Your Ref: A/120/11 Our Ref: PE/ARU/11/11/A Date: 15th September 2011
Contact Name: Phill Edwards Tel: 0845-60-70-999 ext: 40113 Direct Dial No: 01273 404868

Re: Vacant Building at Rustington Golf Centre, Golfers Lane, Angmering, BN16 4NB

Thank you for your letter of 30th August 2011, advising me of a proposed change of use at the above location, for which you seek advice from a crime prevention viewpoint.

Job title:	Family Entertainment Centre
Client:	Rustington Investments Ltd
Drawing title:	Proposed Floor Plan
Status:	Draft
Drawn by:	PP
Date:	12.06
Scale @ A1:	scale @ A3:
1:200	1:200
Job number:	21494
Drawing number:	L 01
Revision:	E

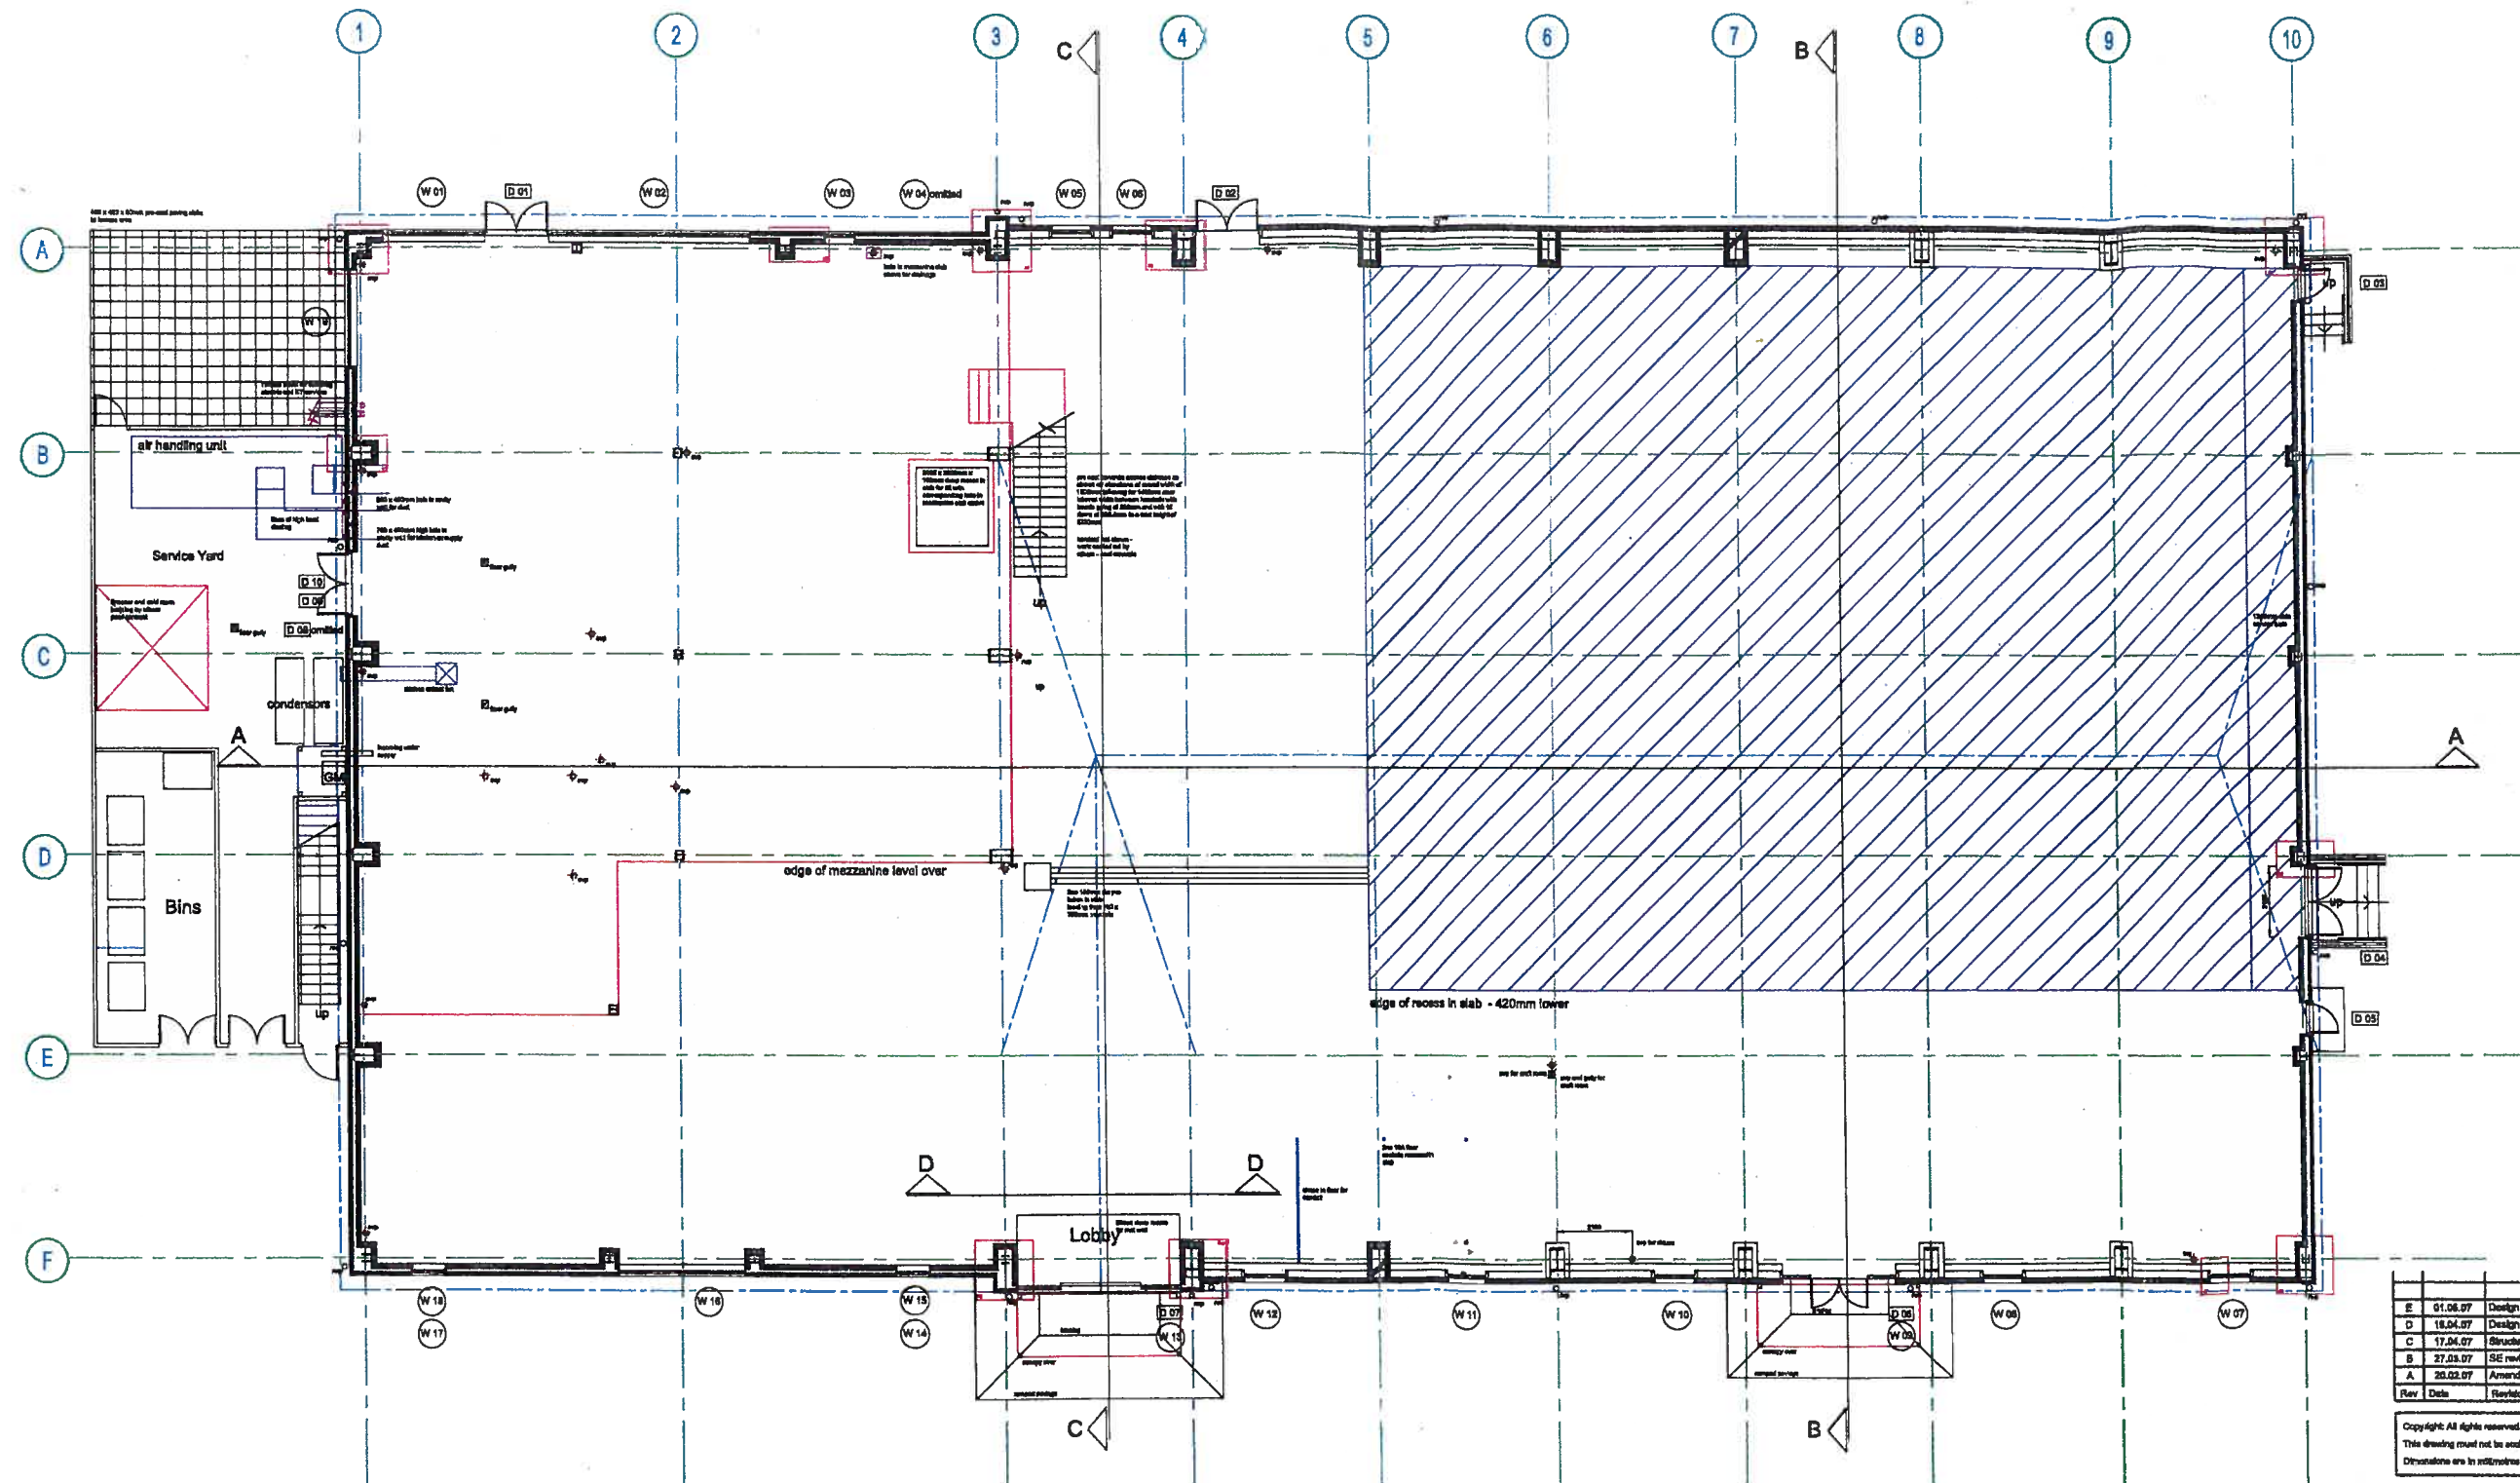
Due to the rural location it will be essential that the building's perimeter is secure and strong. To this end I recommend that all existing doors have locks to BS3621 with any outward opening doors benefiting from hinge pins.

Existing windows if not already with window locks to have them provided.

In order to provide security to the office areas, access control to the offices doors for authorised staff members to be implemented with suitable signage to be prominently displayed.

Job title: Family Entertainment Centre				
client: Rustington Investments Ltd				
drawing title: Proposed Site Plan				
status: Draft	drawn by: PP	date: 03.07	scale @ A1: 1:500	scale @ A3: 1:500
job number: 21494	drawing number: S101	revision: G

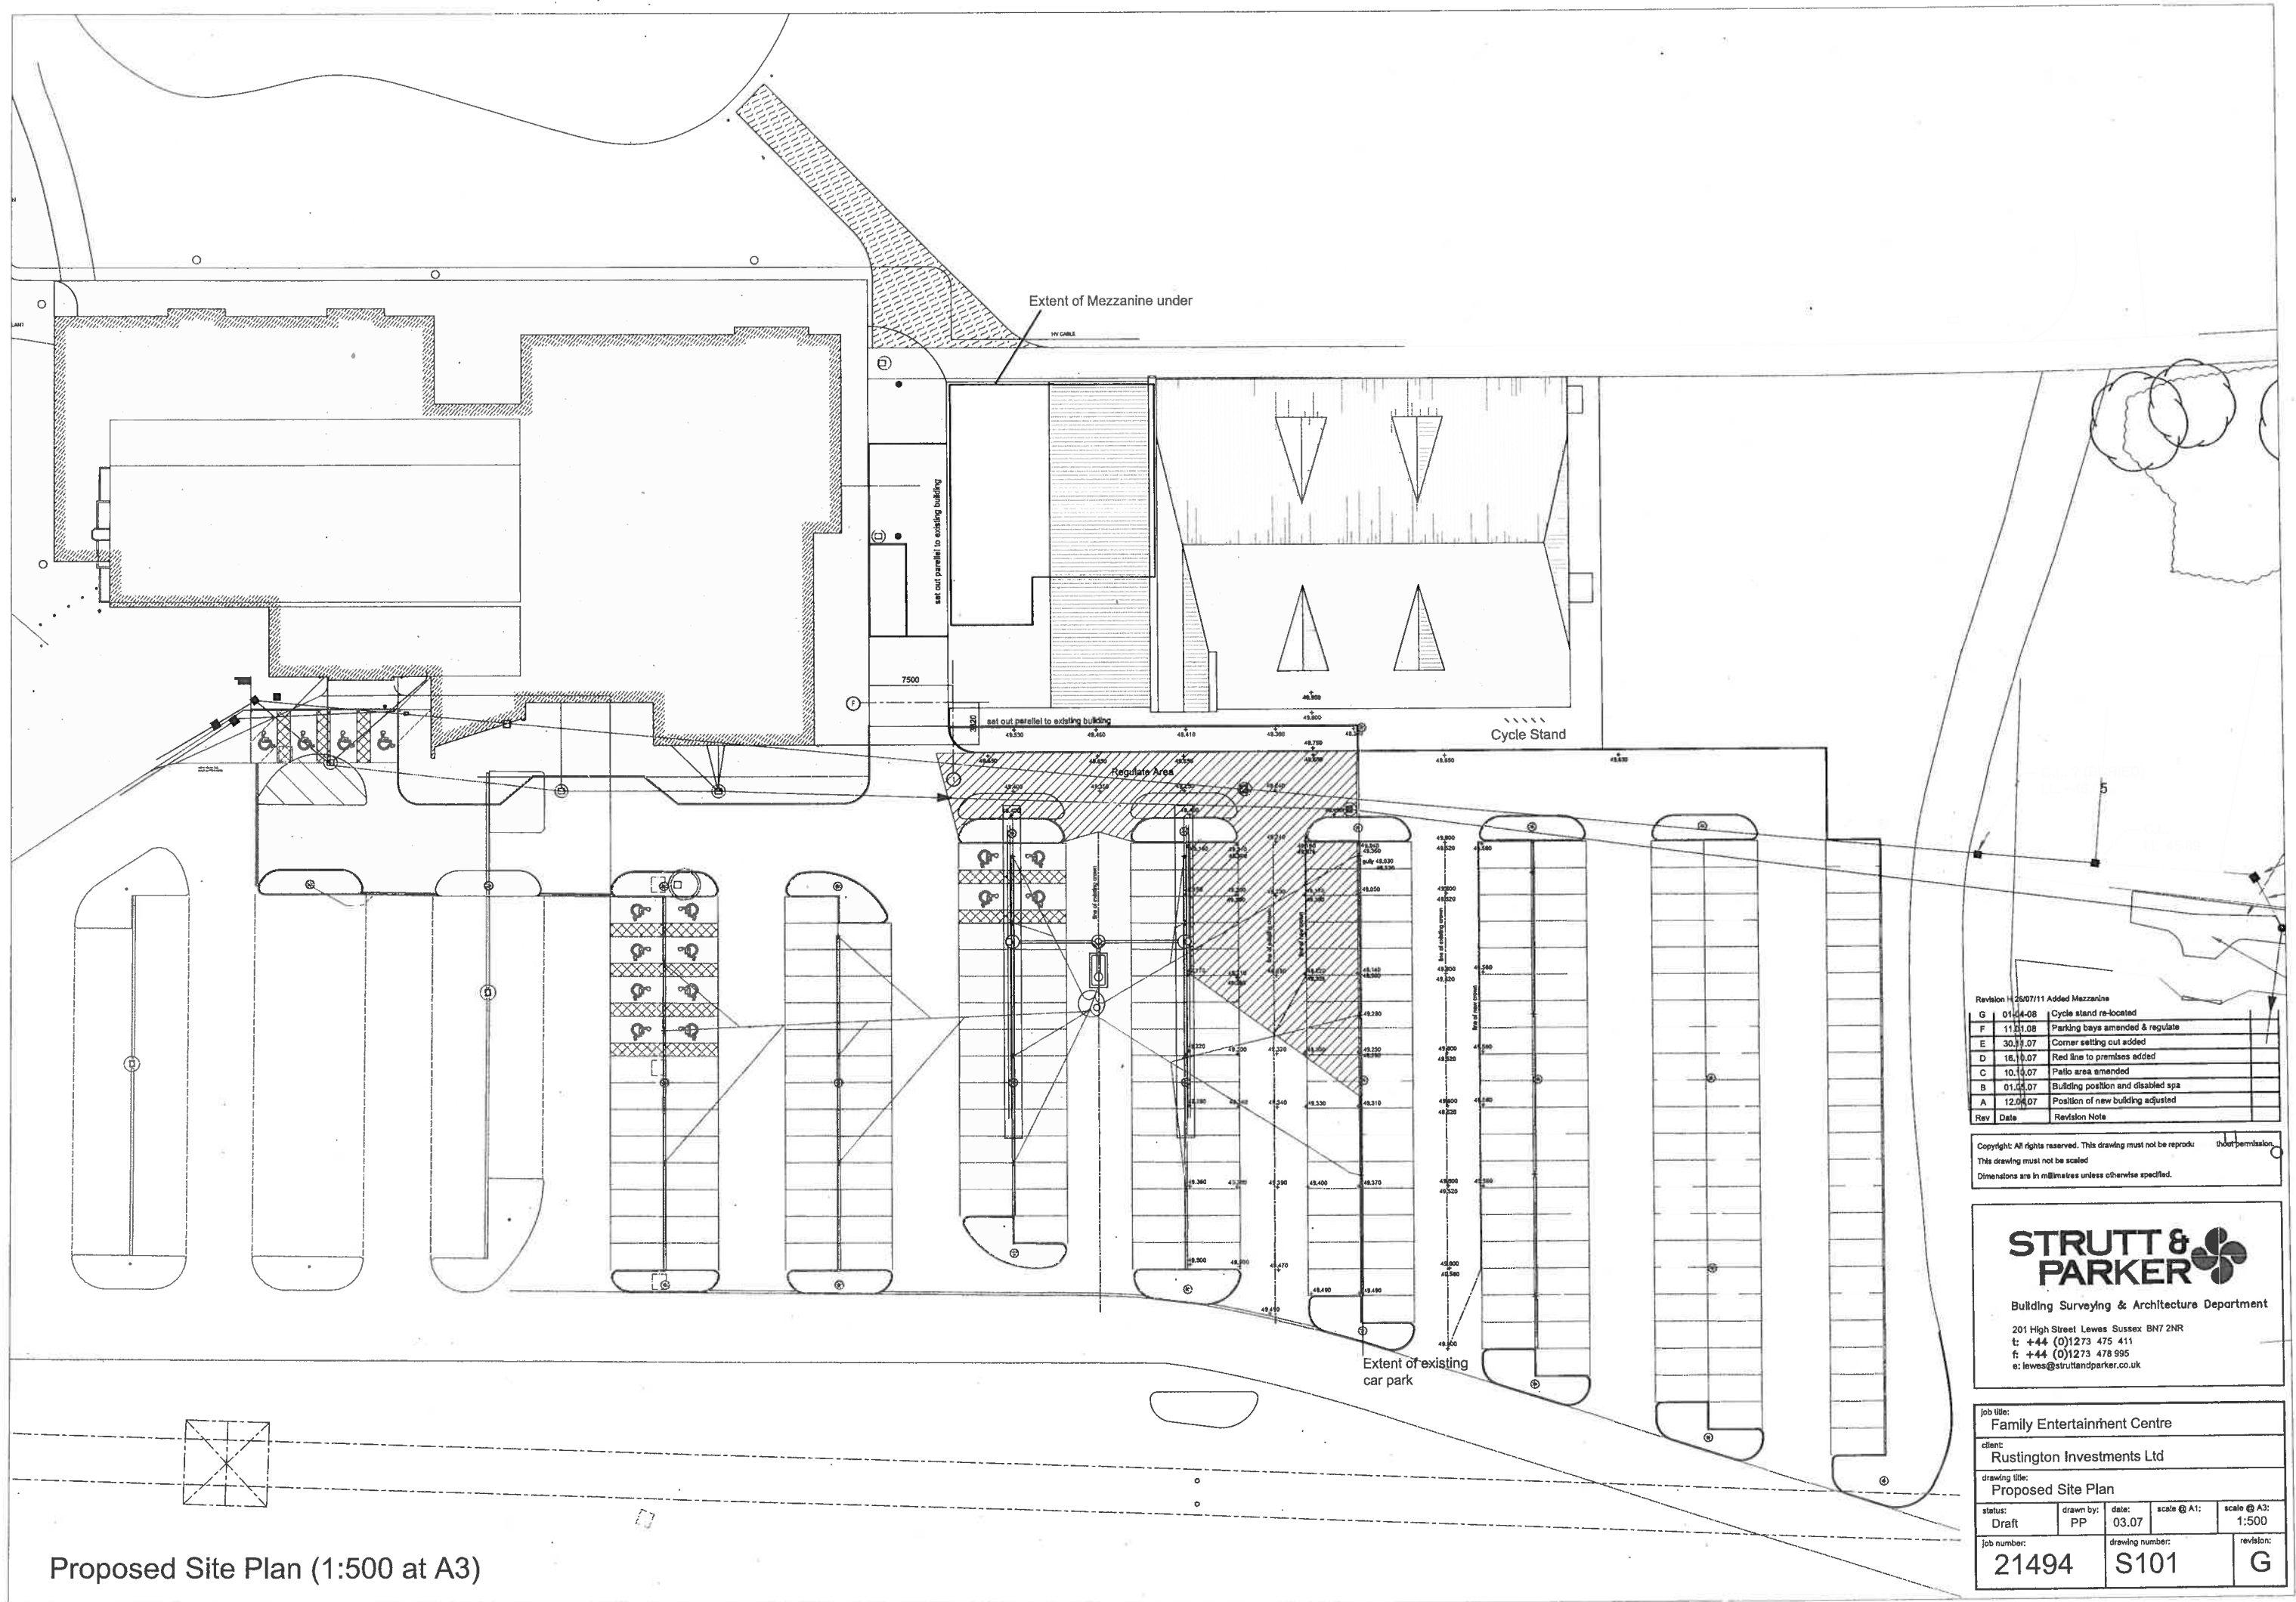
In order to provide a safe and secure environment for staff and customers, adequate fit for purpose lighting is to be installed in the car parking areas, the entrance and exits of the building.
